1999 INWOOD / S. QUORUM - PROPERTY ACQUISITION

January 21, 1999

Re: Inwood/S. Quorum Project

LOT 2, BLOCK 1
WELLINGTON SQUARE
V. 79220, P. 2203
DRDCT

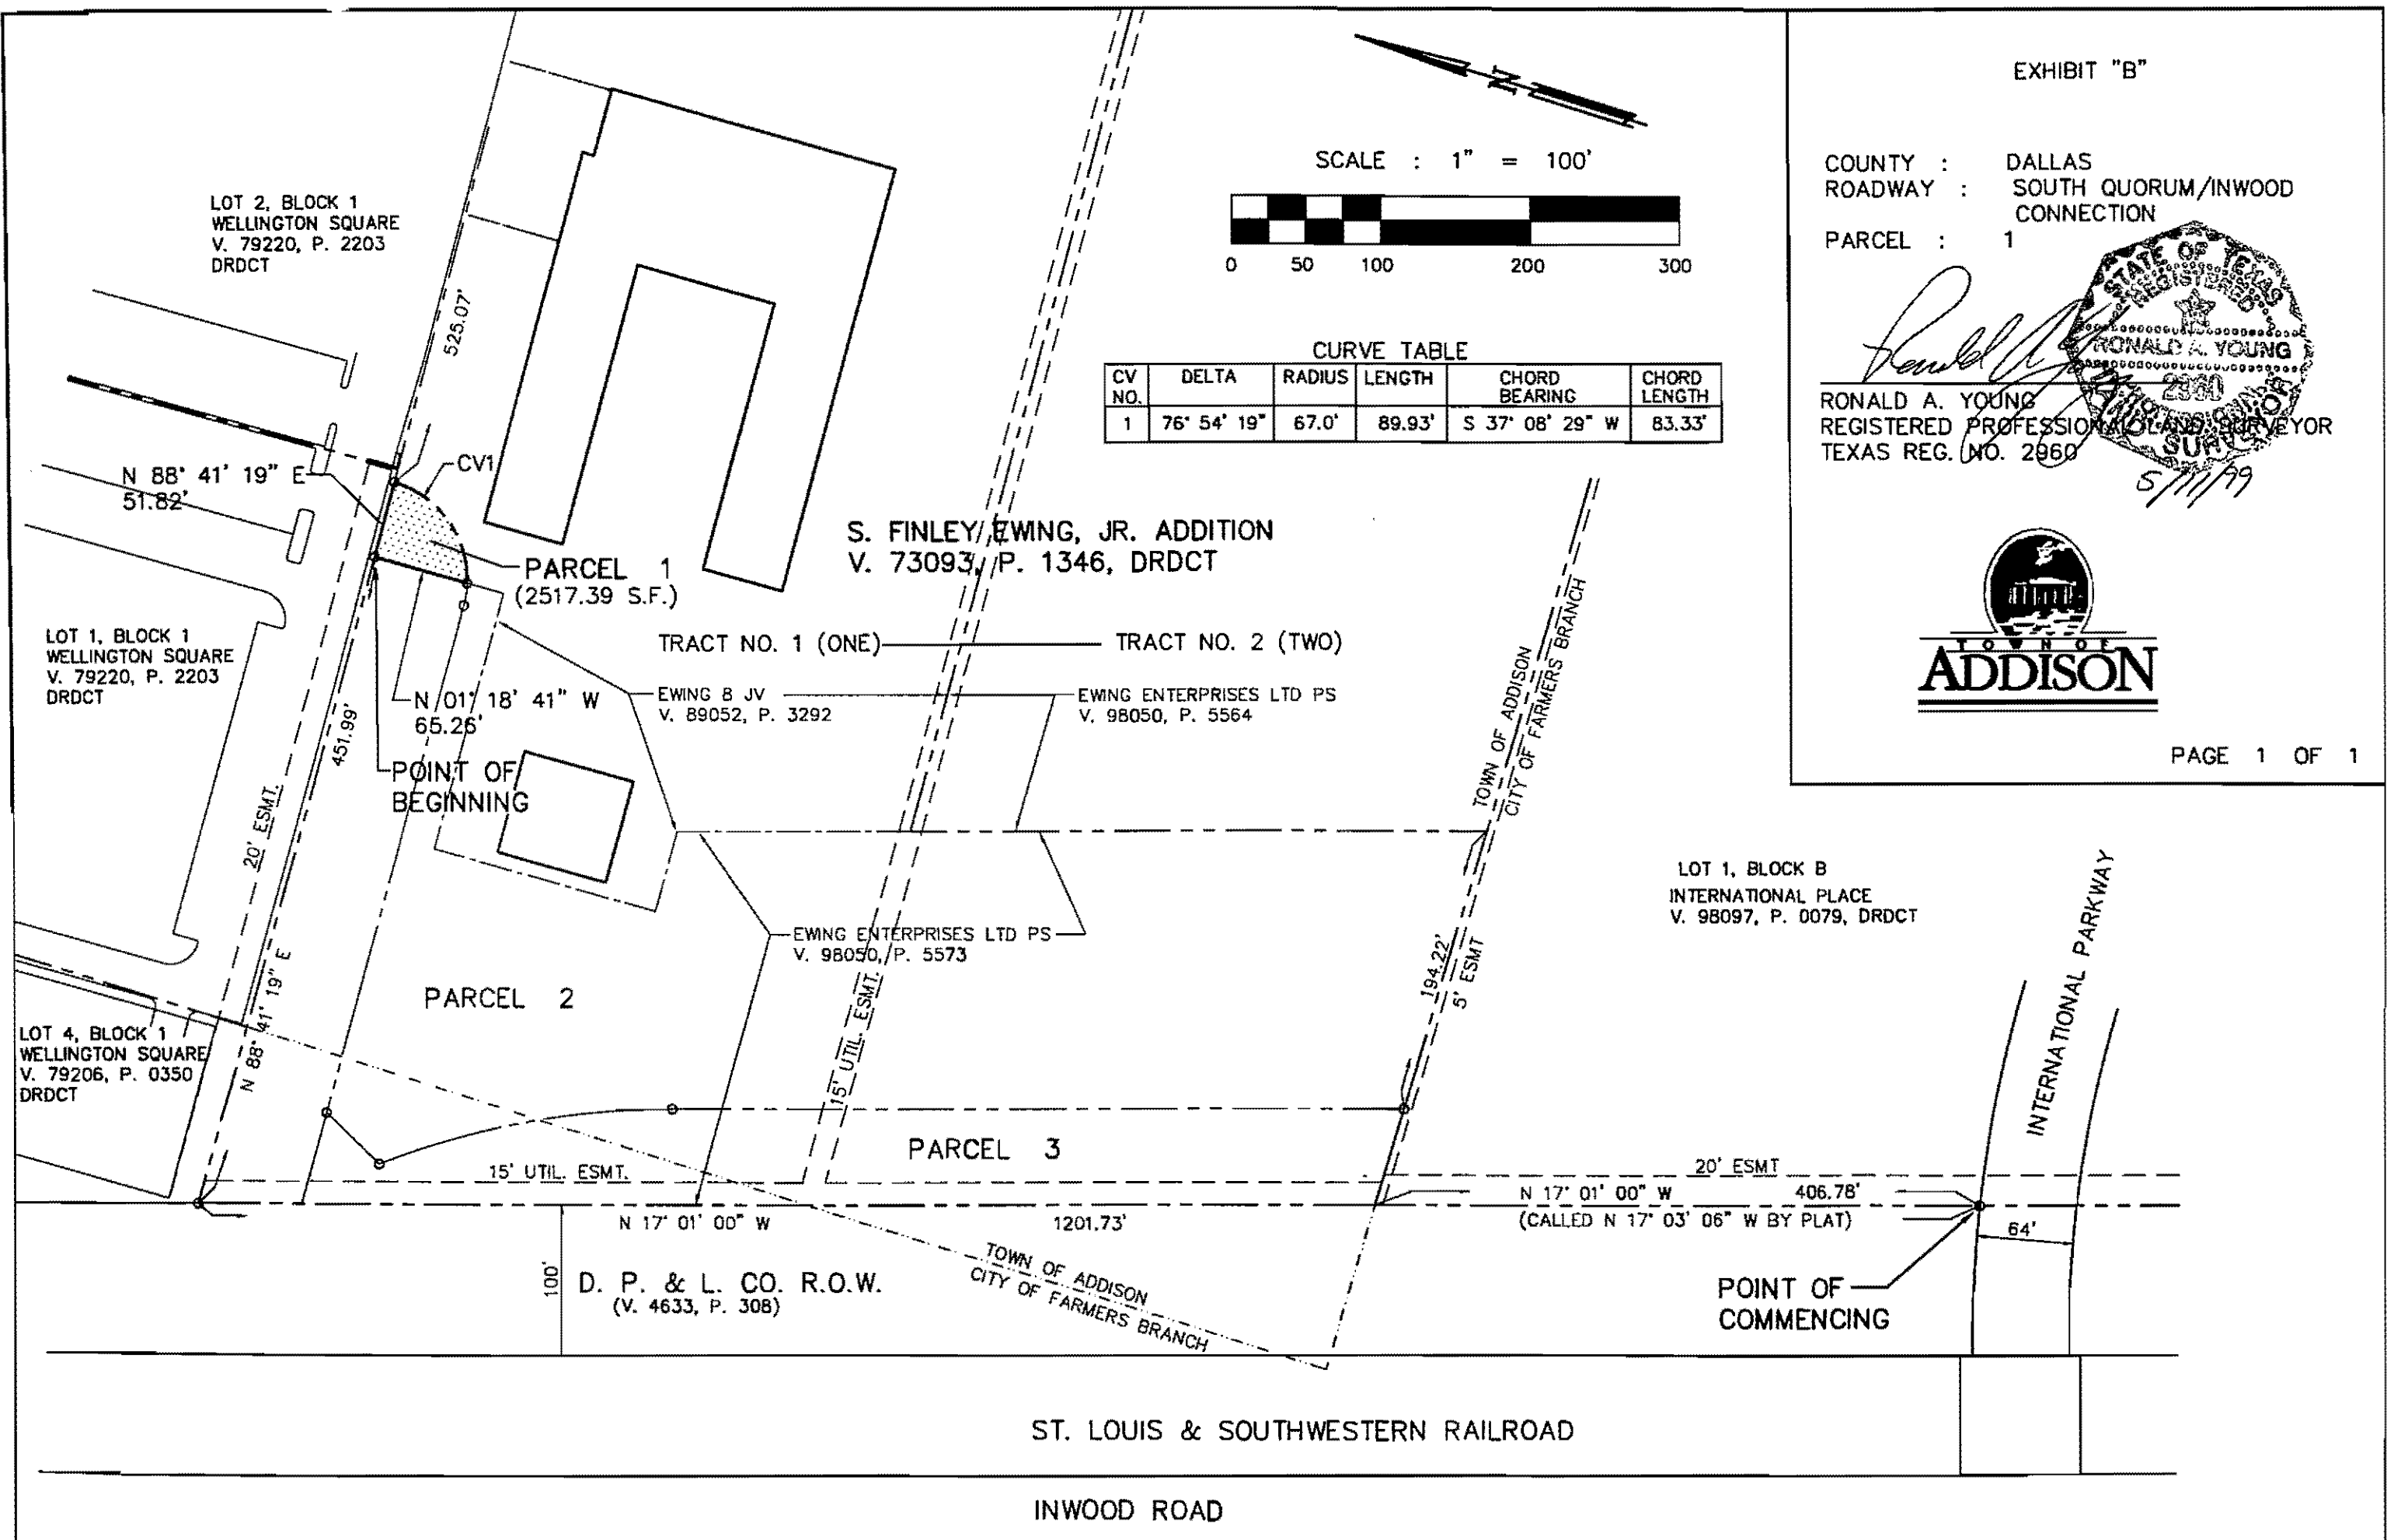
- The width of the East-West portion of Parcel 2 will be reduced by 3 feet. This will also affect Parcel 1. Parsons Transportation Group is preparing revised metes and bounds.

COUNTY : DALLAS
 ROADWAY : SOUTH QUORUM/INWOOD CONNECTION
 PARCEL : 2

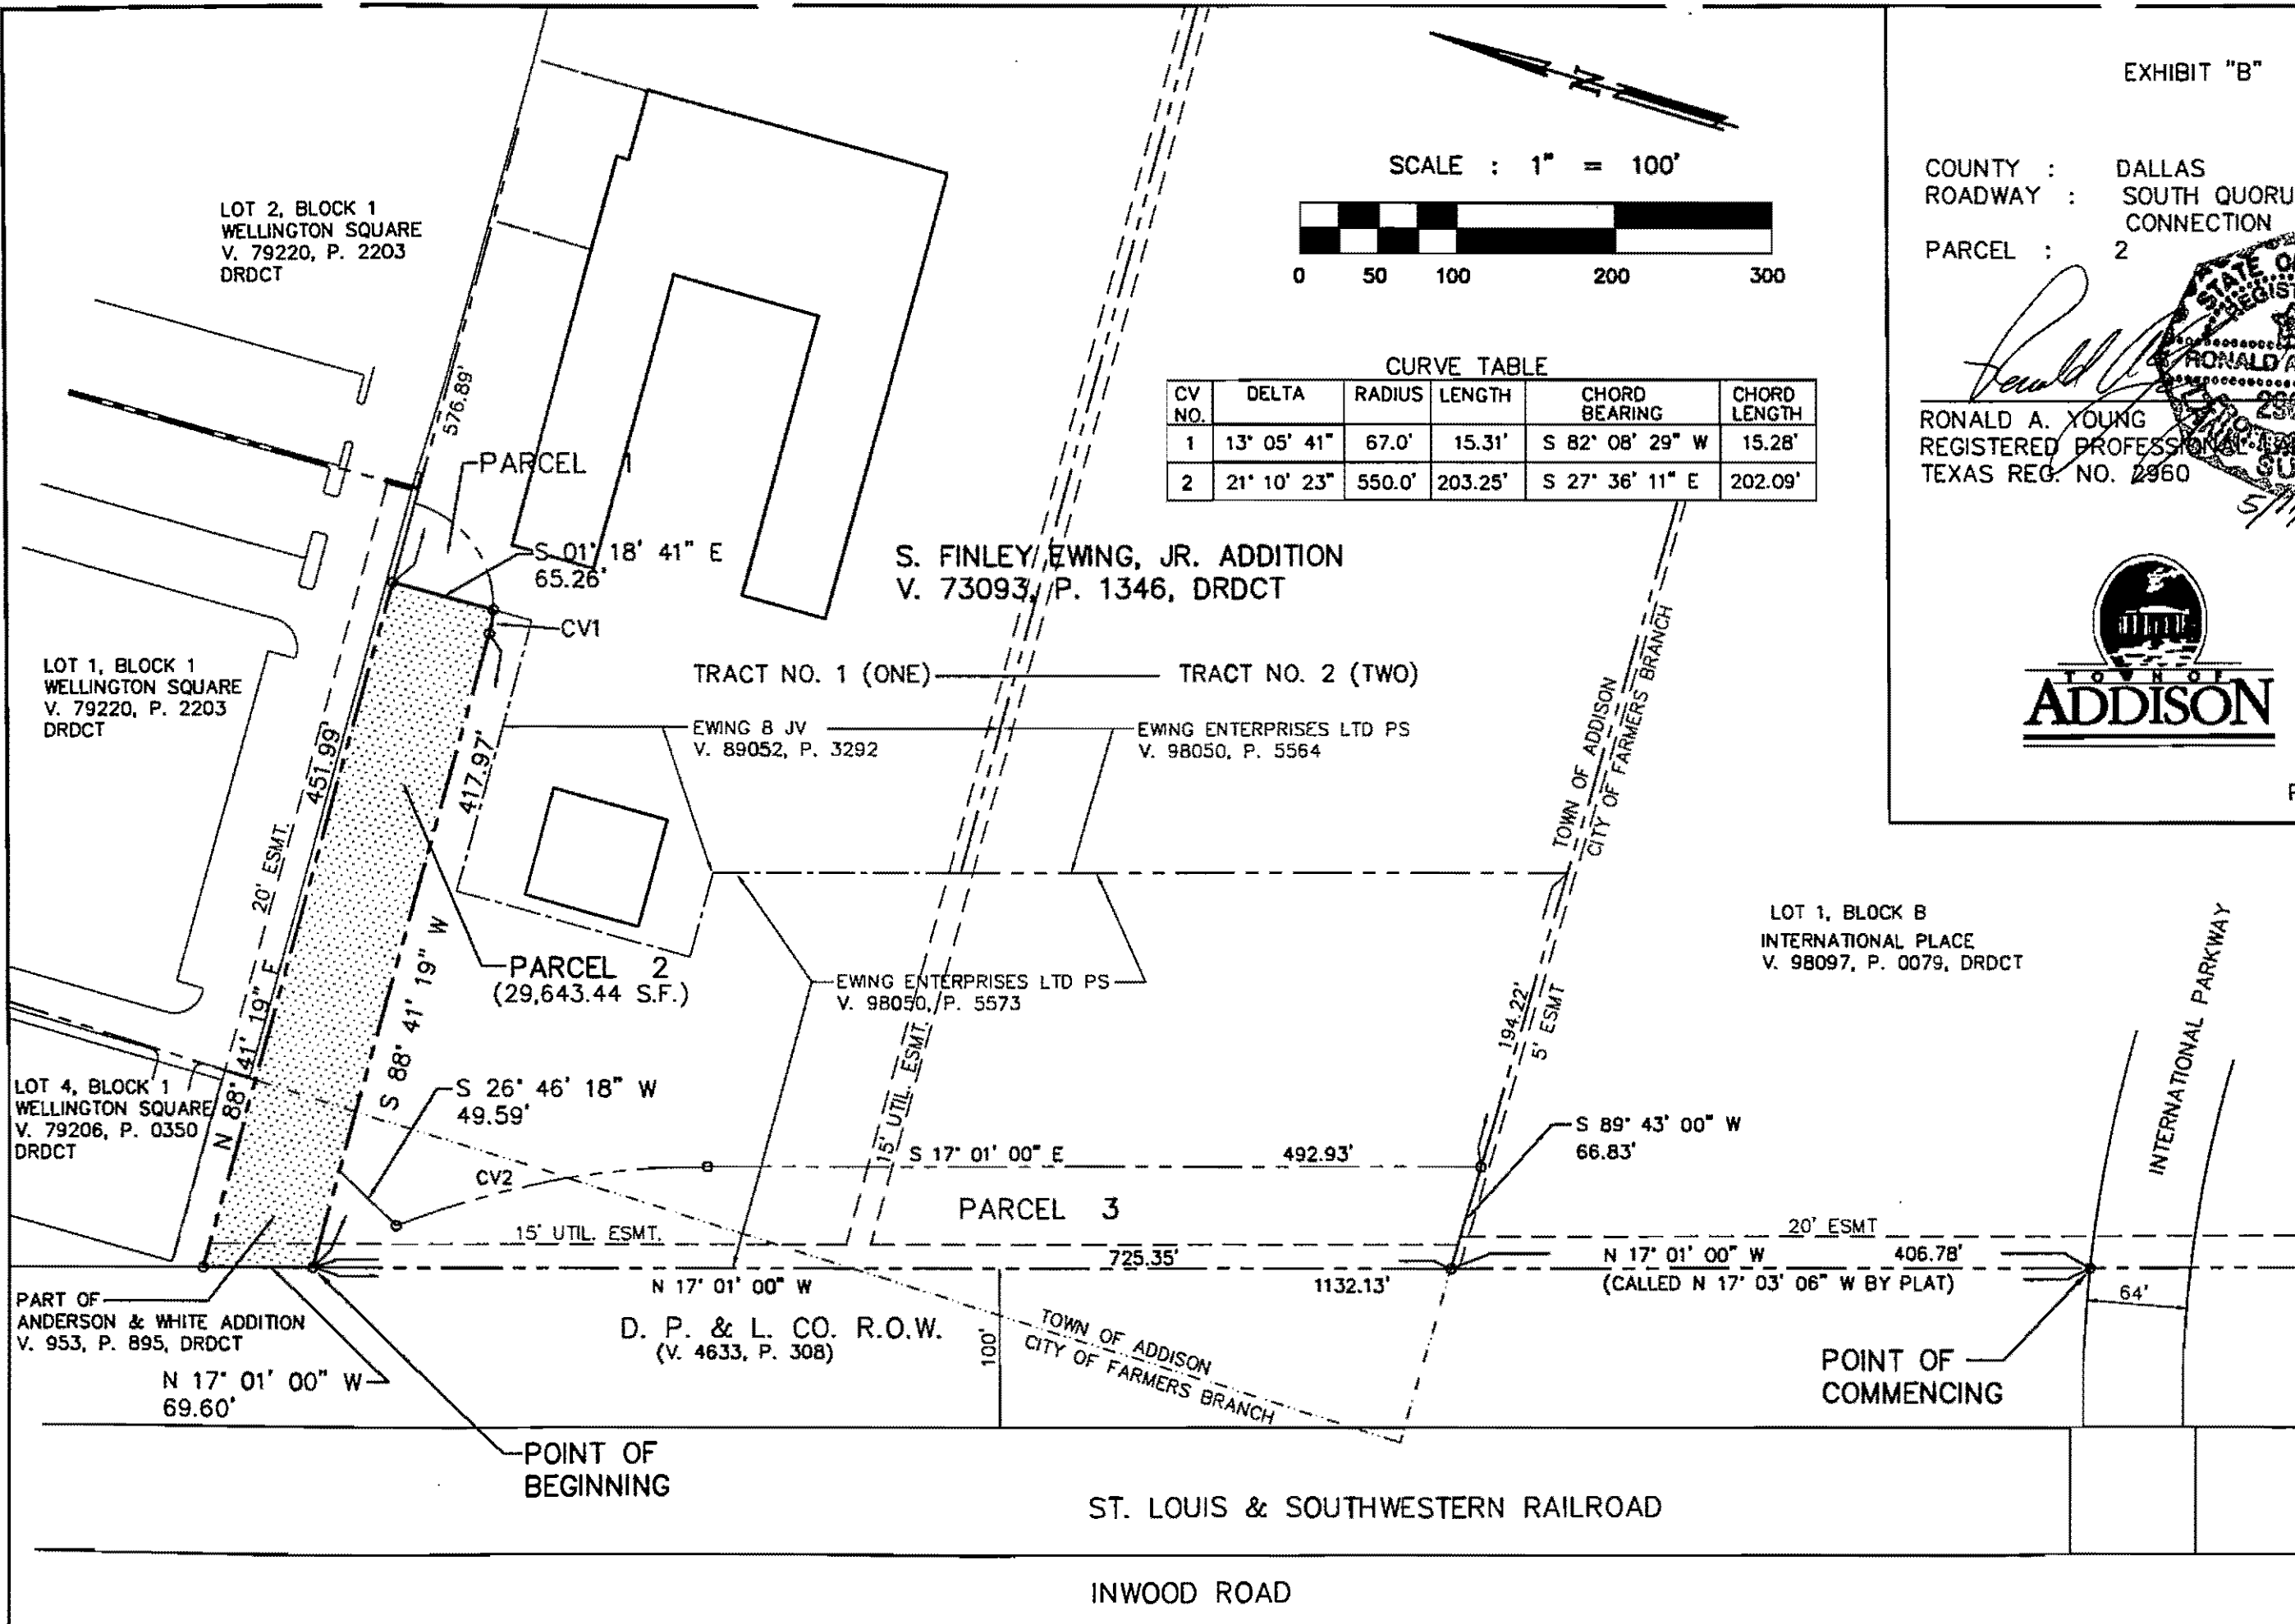
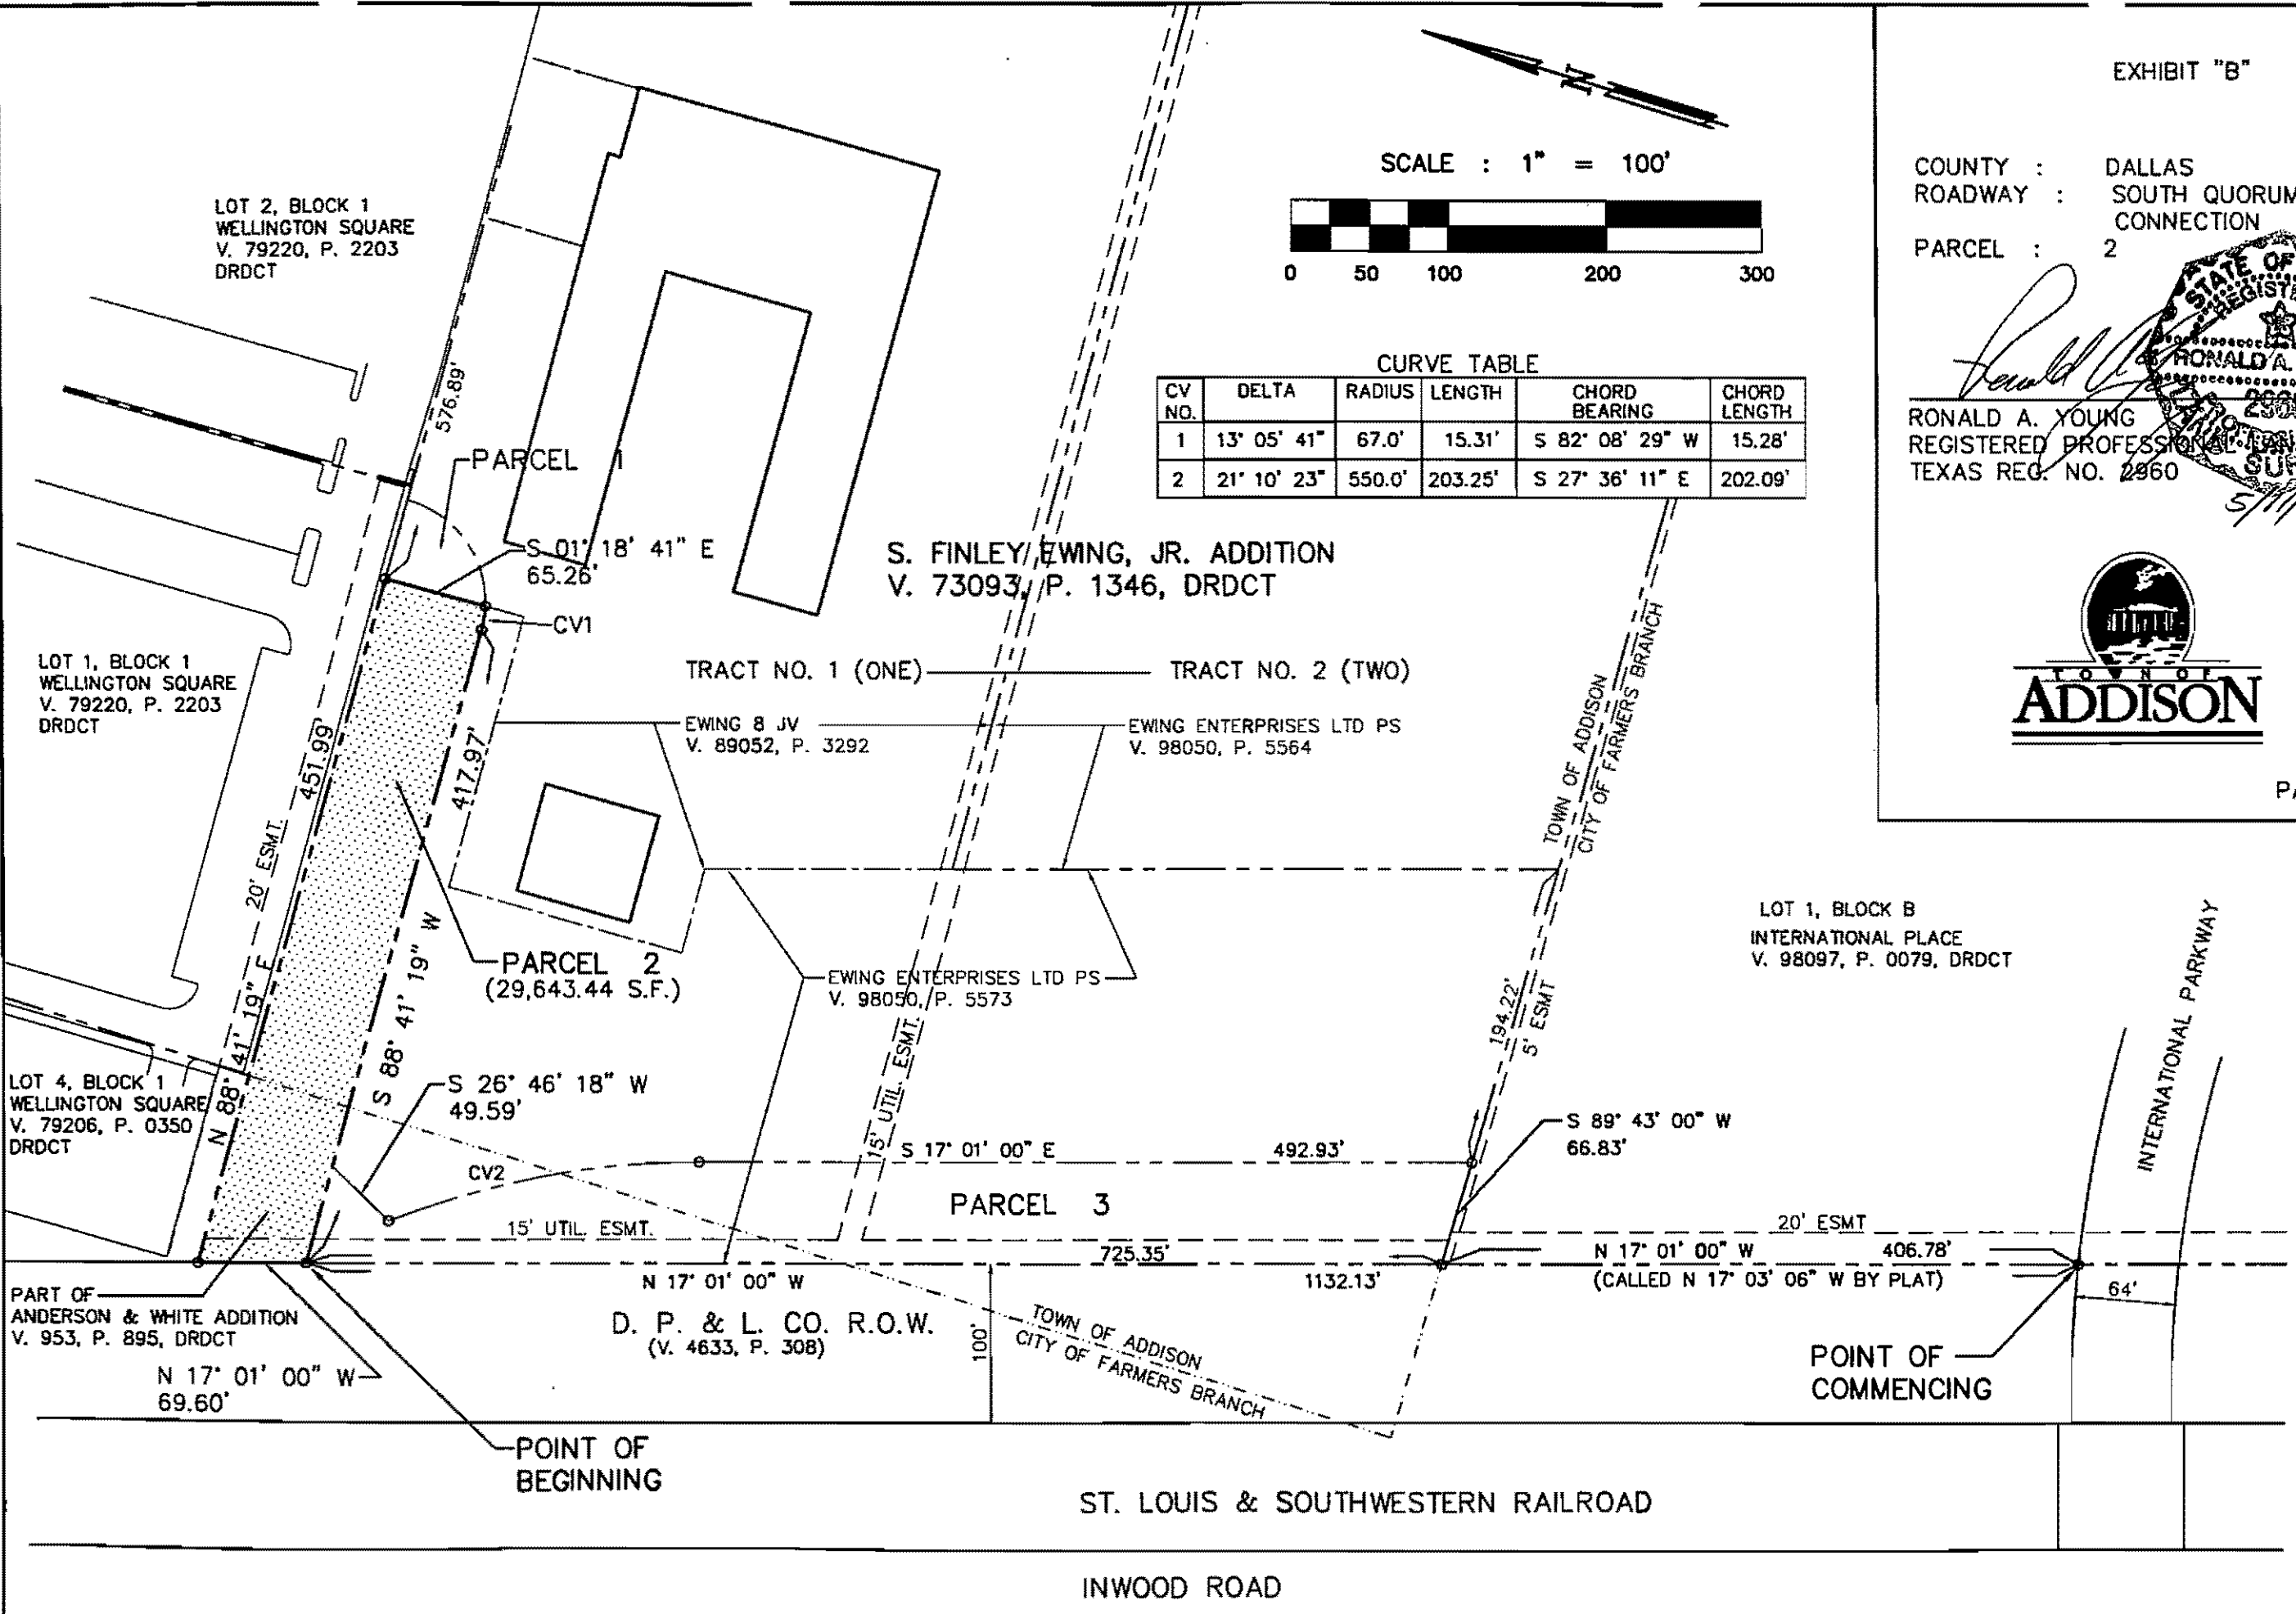
Comments: We met with owner & lease holder  
and based on the "paint layout", we  
agreed to take 3' off the width of  
the parkway to give more clearance  
between the corner of the garage and the  
ROW line. This would give 22' between  
the two. However, based on the attached  
CAD drawing, the road looks a little  
mis-aligned. Please review. We need to  
work this out and I ~~was~~ need new metes  
& bounds & maps to reflect the changes.  
Please call and lets discuss.
